Application Reference Number:	2025/0465		
Application Type:	Householder		
Proposal Description:	Proposed erection of single storey side extension and formation of new access for the parking of 2no. vehicles		
Location:	9 Springvale Avenue, Worsbrough, Barnsley, S70 5JU		
Applicant:	Mr Liam Exley		
Third-party representations:	None	Parish:	None
		Ward:	Worsbrough

This planning application has been submitted by Mr Liam Exley and seeks householder planning permission for a single storey side extension and a new access and parking area.

Ref.	Dwg. No.	Rev.
2025/27	02	E

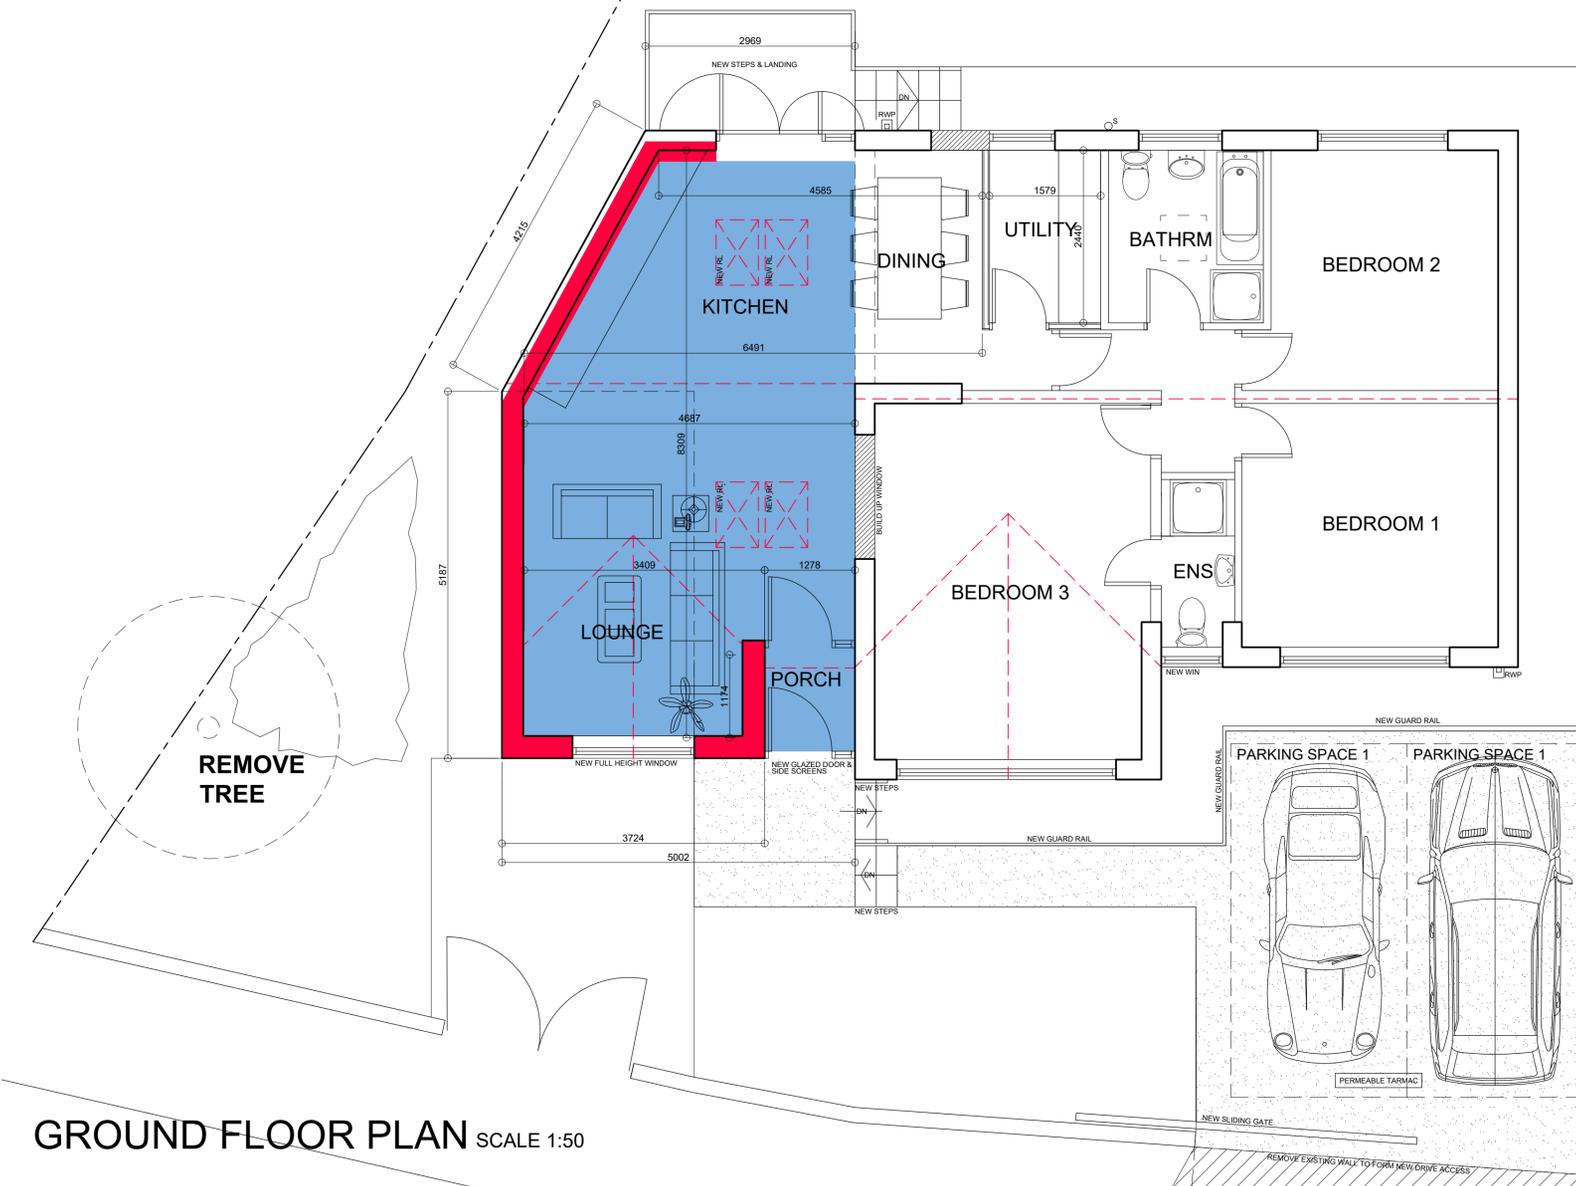
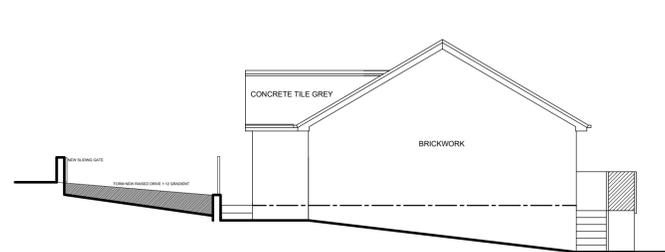
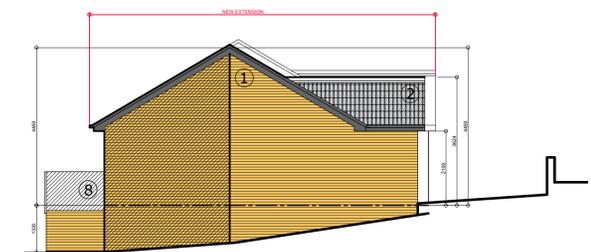
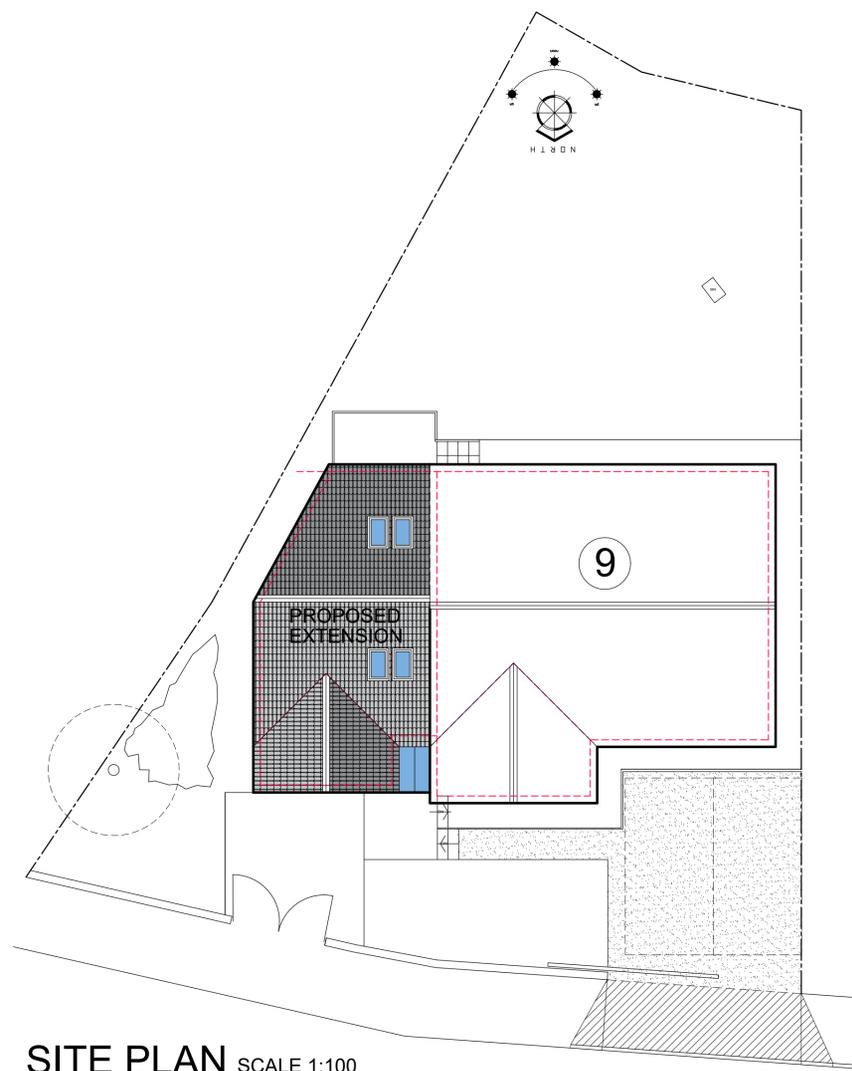
The SPD states that single storey side extensions “*should not have an excessive sideways projection (i.e. more than two thirds the width of the original dwelling)*”. The design is in keeping with the existing dwelling and the proposed extension has a projection of 5 metres, which is less than two thirds the width of the original dwelling. This is therefore acceptable in line with the above recommendation. This weighs significantly in favour of the proposal. The proposed extension will not have a significant detrimental impact on any neighbouring property by way of overshadowing or being overbearing due to its modest projection and replacing an existing garage structure. The extension is not of an excessive size or scale and is an extension of the existing building form rather than a separate, stand-alone addition and is therefore subservient to the existing dwelling.

Equally, it is not considered overbearing due to its restrained size and massing. Potential overlooking will also be limited with no windows proposed on the side elevation. New steps to the rear and a landing are proposed that are 1.15 metres high however this will also not contribute to significant overlooking due to the small space available. Over 10 metres is also retained to the rear boundary and the proposed dwelling to the rear is over 21 metres away. This weighs moderately in favour of the proposal. The proposal is considered to be in compliance with Local Plan Policy GD1: General Development and is acceptable in terms of residential amenity.

The proposed extension utilises a pitched roof which is akin to the existing dwelling’s pitched roof and is therefore acceptable. The proposed roof is also set down from the existing dwelling’s roof and the extension is setback 0.3 metres from the existing dwelling’s front elevation which adds a visual break between the two. This weighs significantly in favour of the proposal. The proposed extension conforms to the SPD in terms of its external materials and roof type; therefore, it will have little impact upon the character of the street scene. The proposed development is therefore not considered to be contrary to Local Plan Policy D1: High Quality Design and Place Making and is considered acceptable in terms of visual amenity.

There will be no impact upon highway safety. The proposal would increase the number of bedrooms in the dwelling from two to three thus increasing the on-site parking requirement to two. To ensure the property retains adequate off-street parking even with the loss of the garage, it is intended to create a new driveway space to the front of the dwelling to allow two vehicles to park. It is anticipated that all servicing arrangements will be unchanged. The scheme is acceptable from the perspective of highways. This weighs significantly in favour of the proposal.

- Addition of setback to the proposed extension.
